Tower Club/Coco Lounge
8-10 Clifton Road
Littlehampton
West Sussex
BN17 5AS

Our Ref: LU/264/18/PL

**Town & Country Planning Act 1990 (as amended)
Town and Country Planning (Development Management Procedure) (England) Order 2015
Application for Full Planning Permission**

Development Change of use from redundant function room to office.
Location 8 - 10 Clifton Road Littlehampton

EXISTING FIRST
FLOOR PLAN
1:50

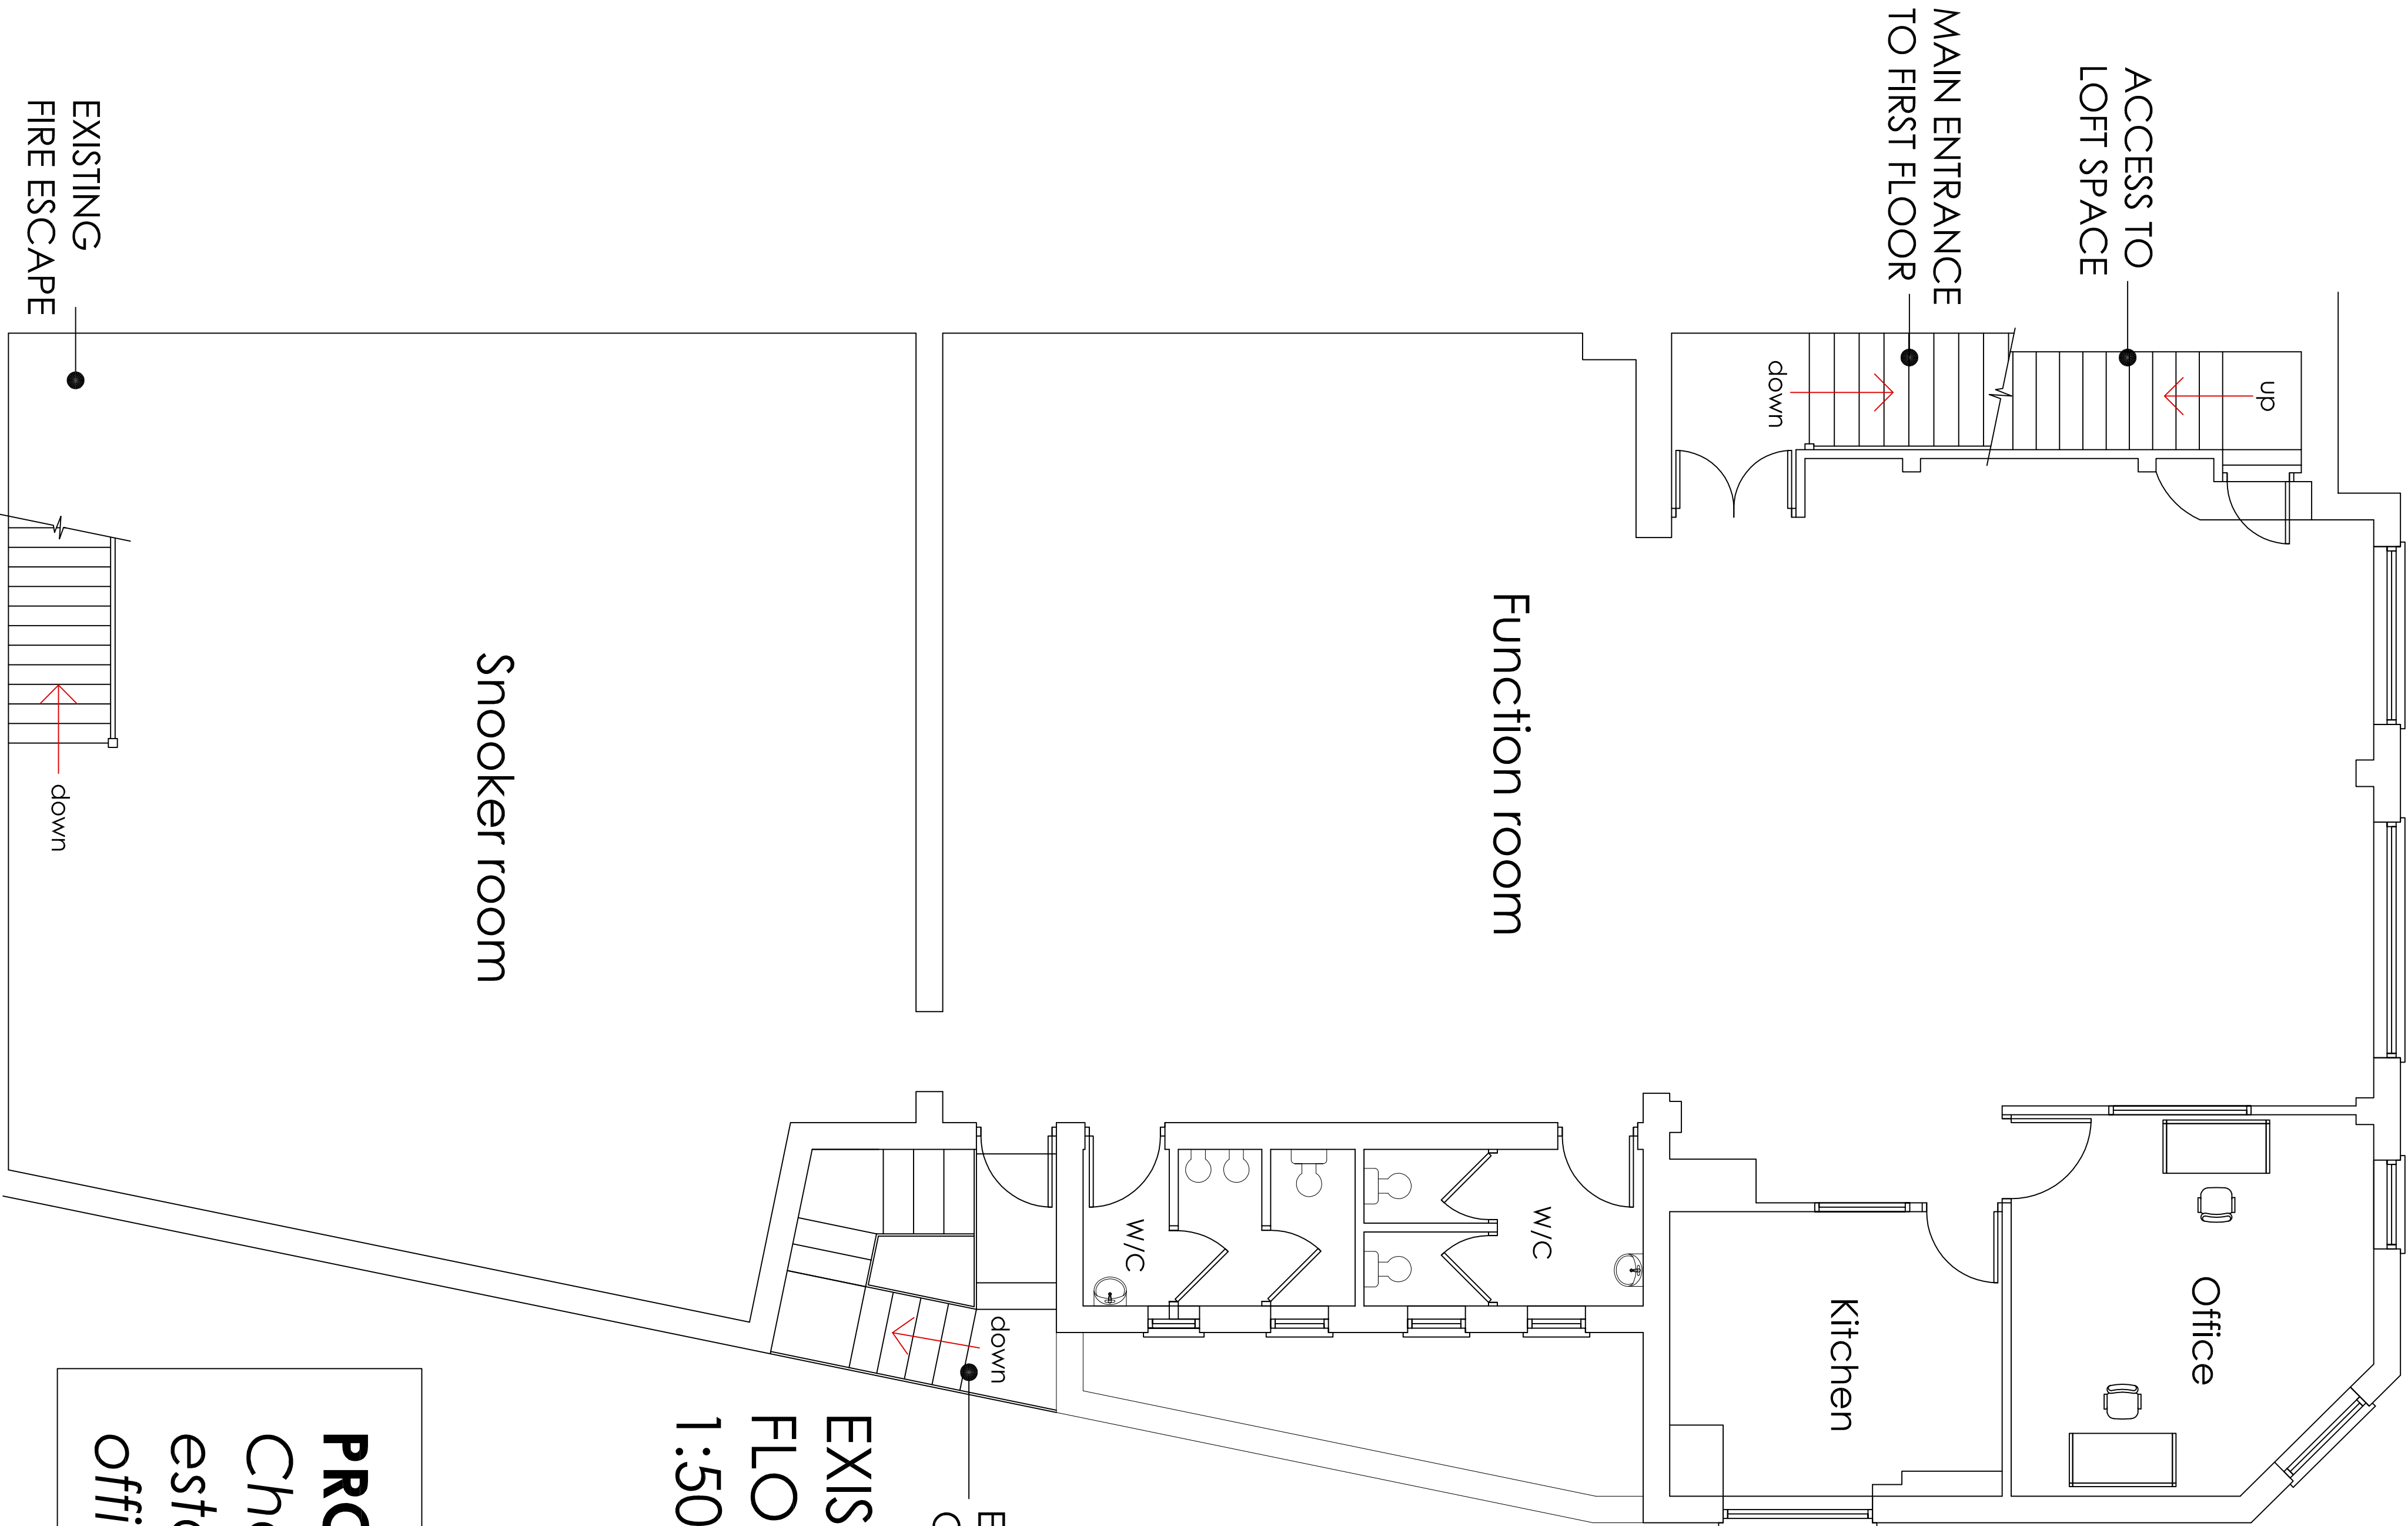
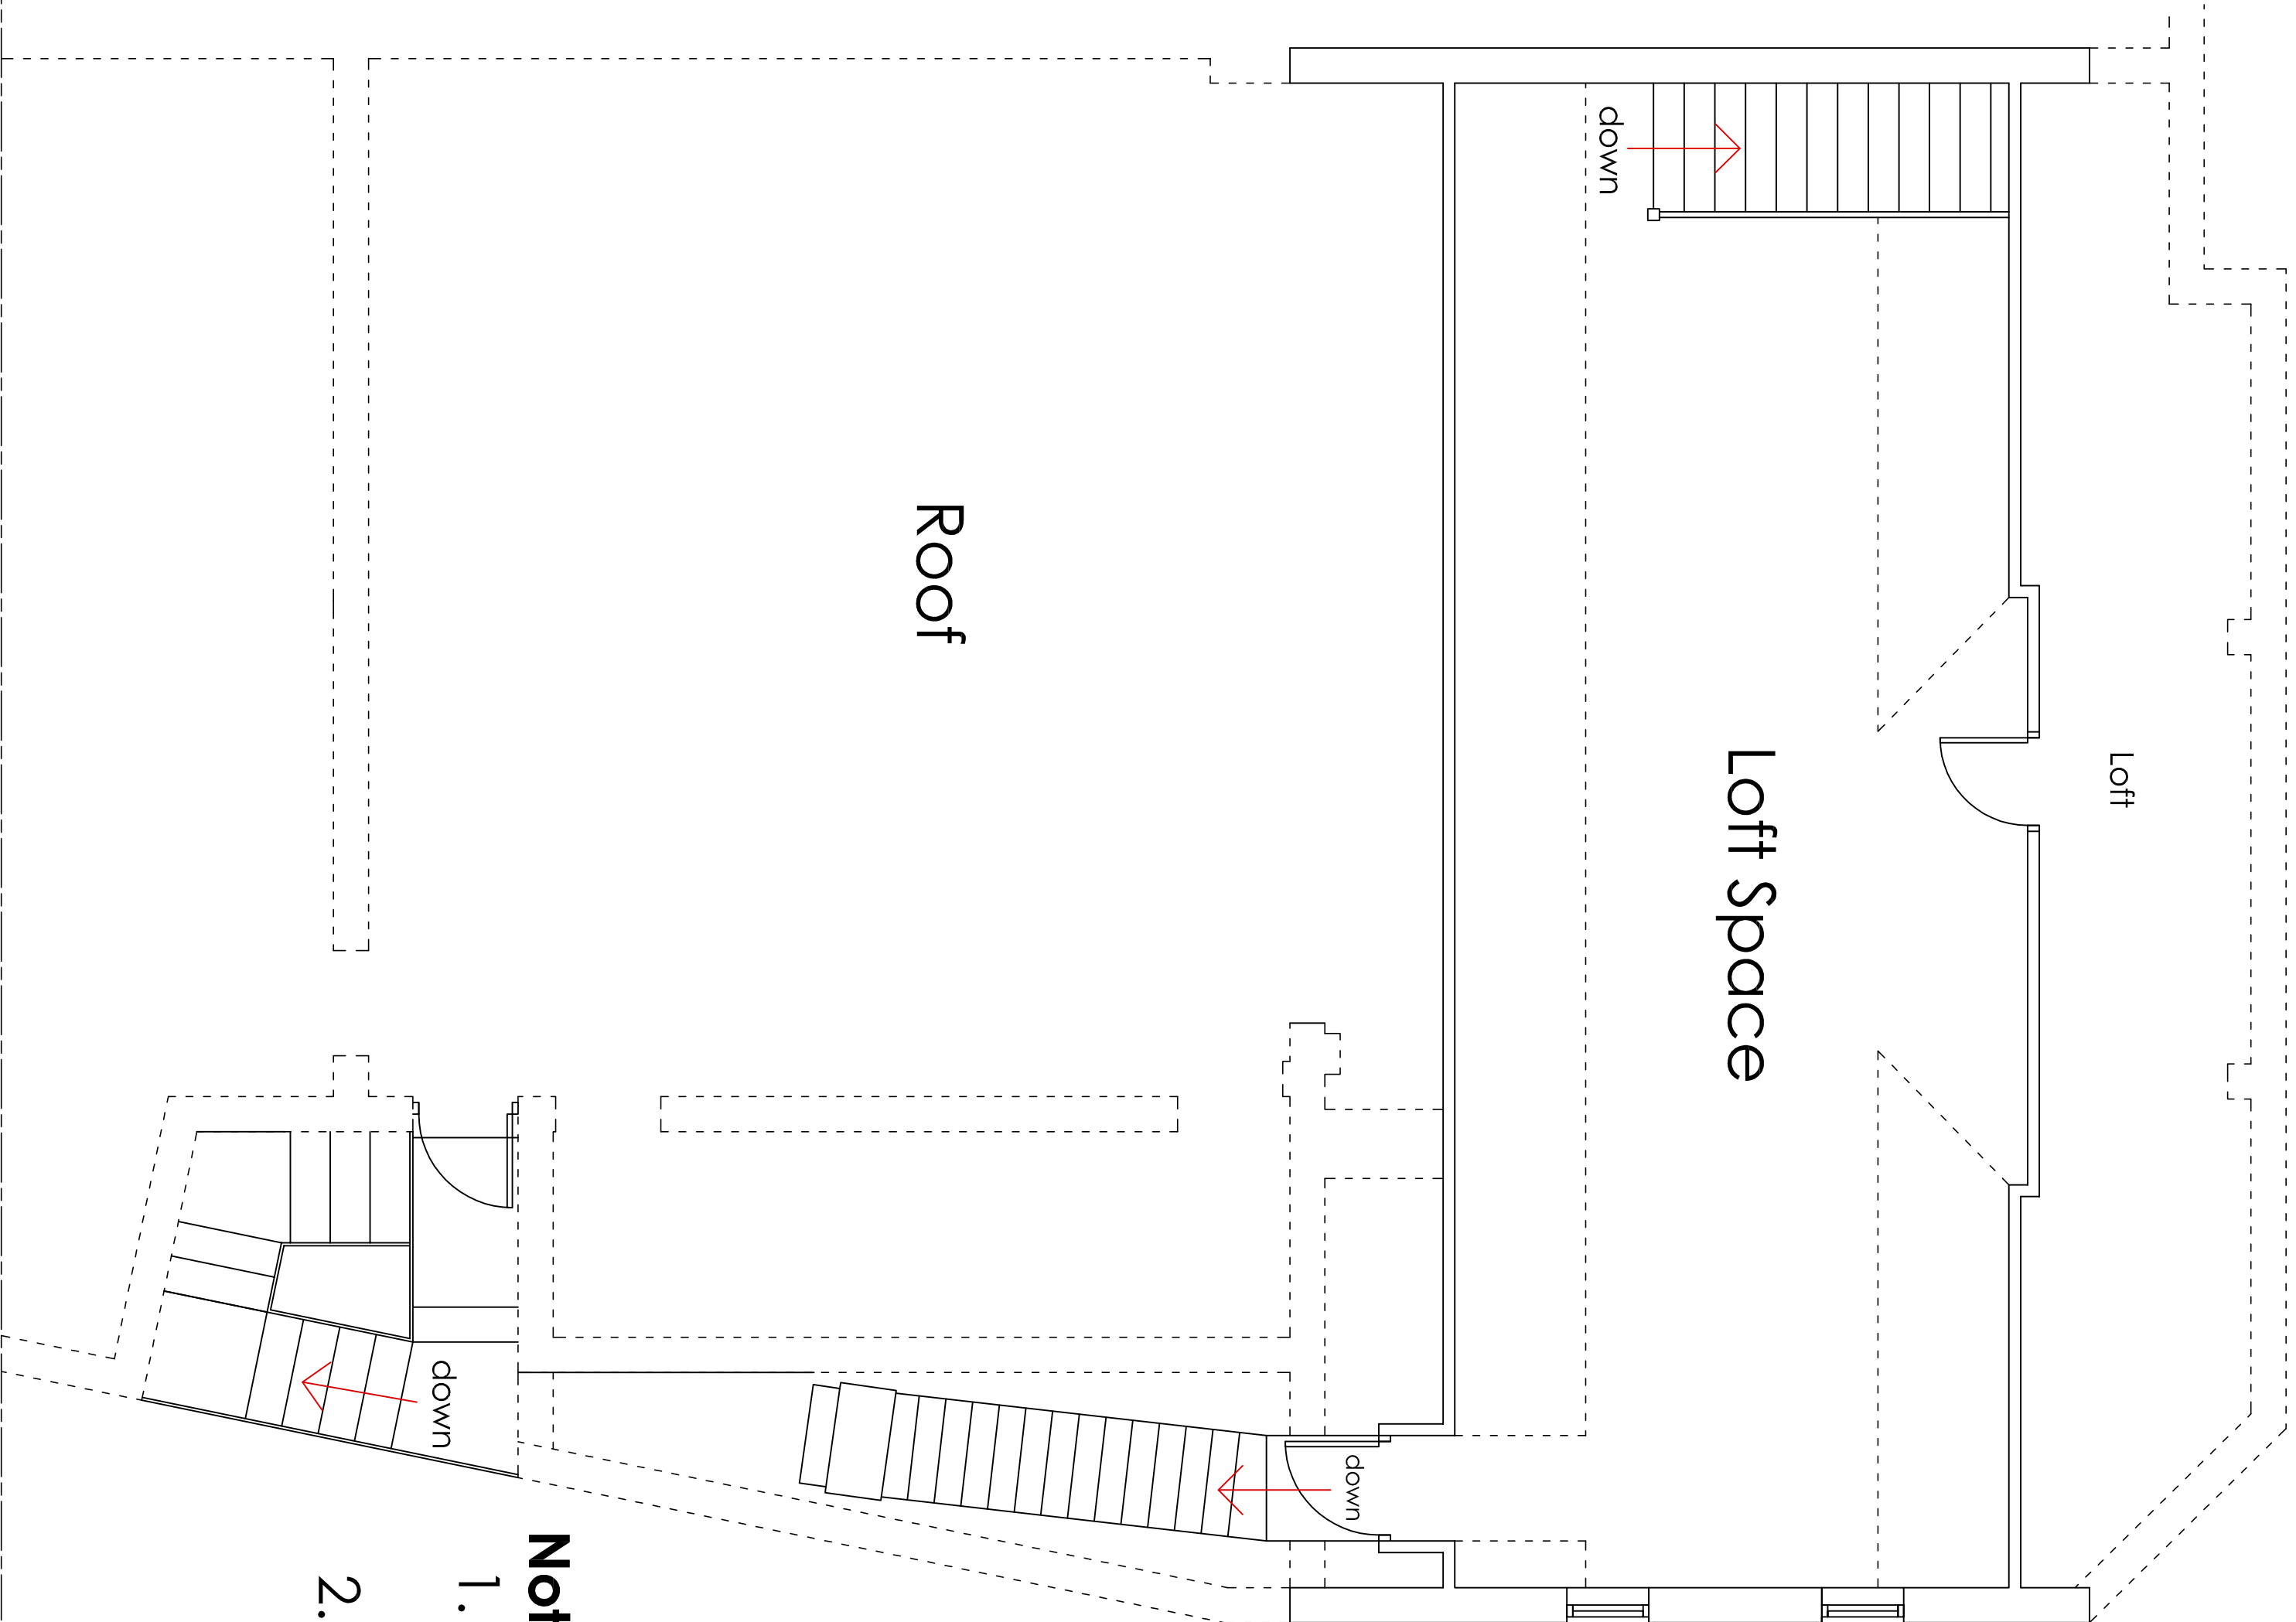
Please provide a scale for the existing and proposed floor plans (the plans that were submitted on A3 paper) and provide a scale or measurements on the plans.

SITE PLAN 1:500

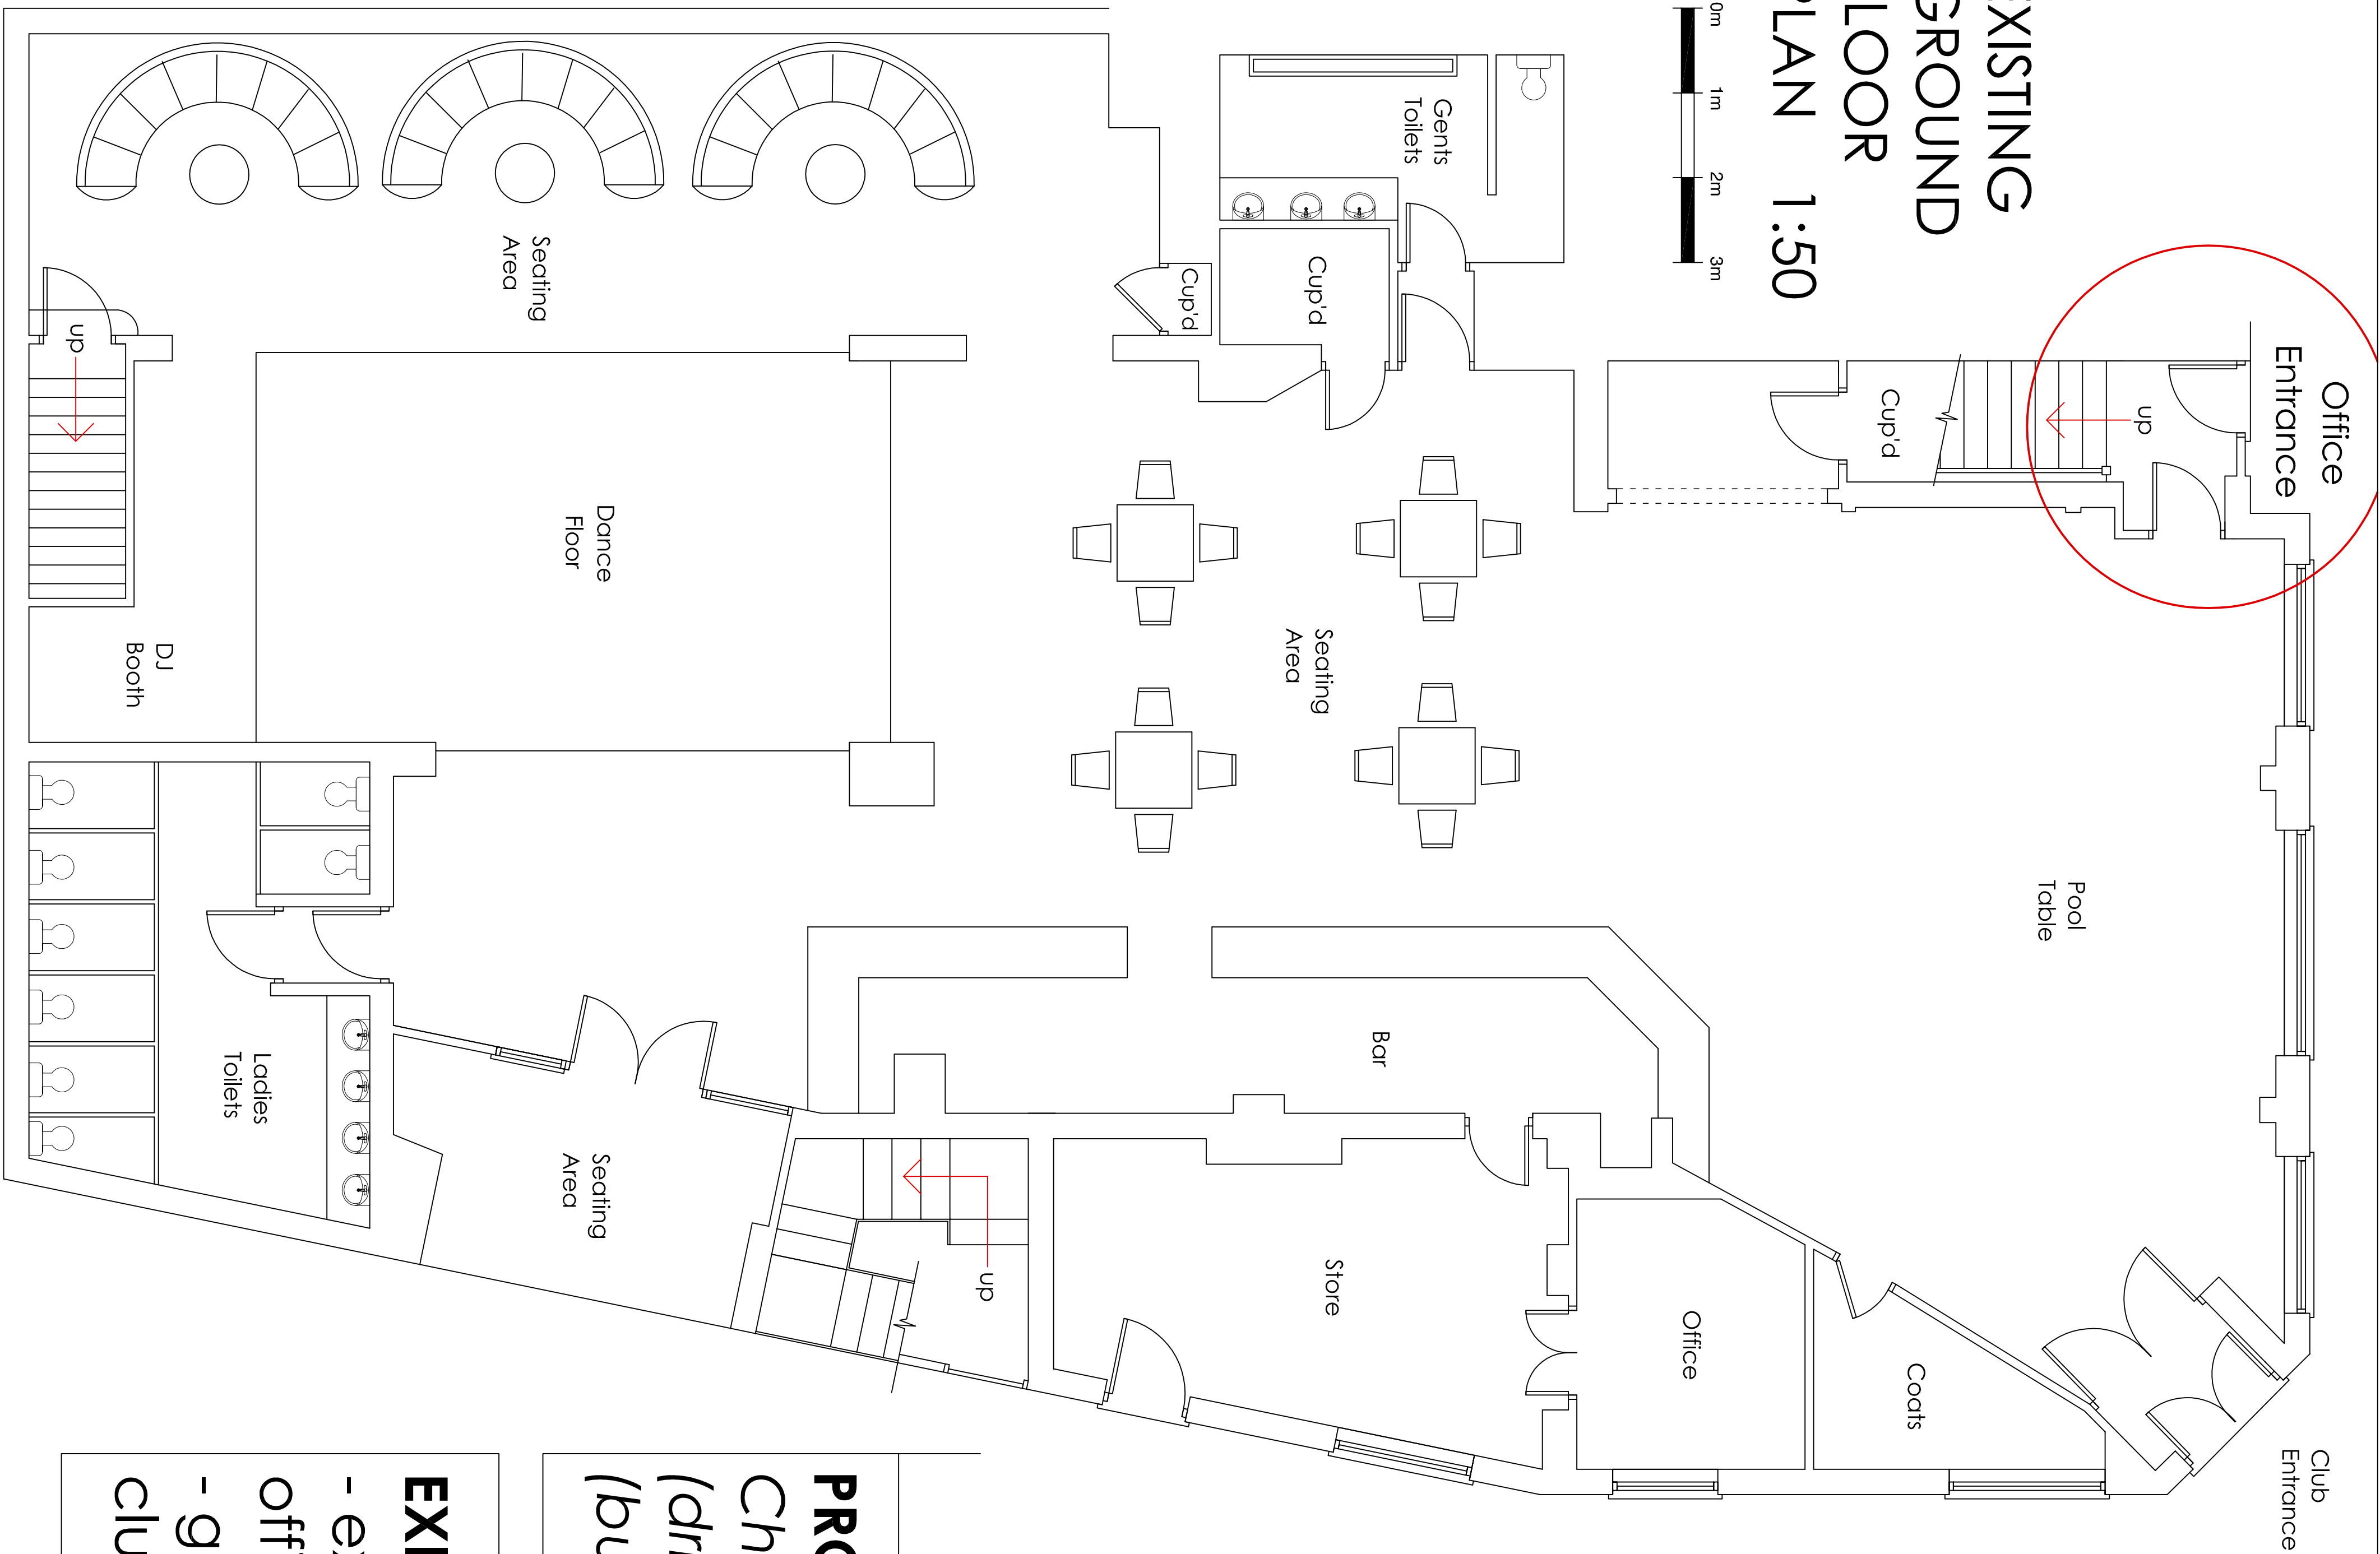
Block Plan Amend

Please hatch the area of the proposed office.
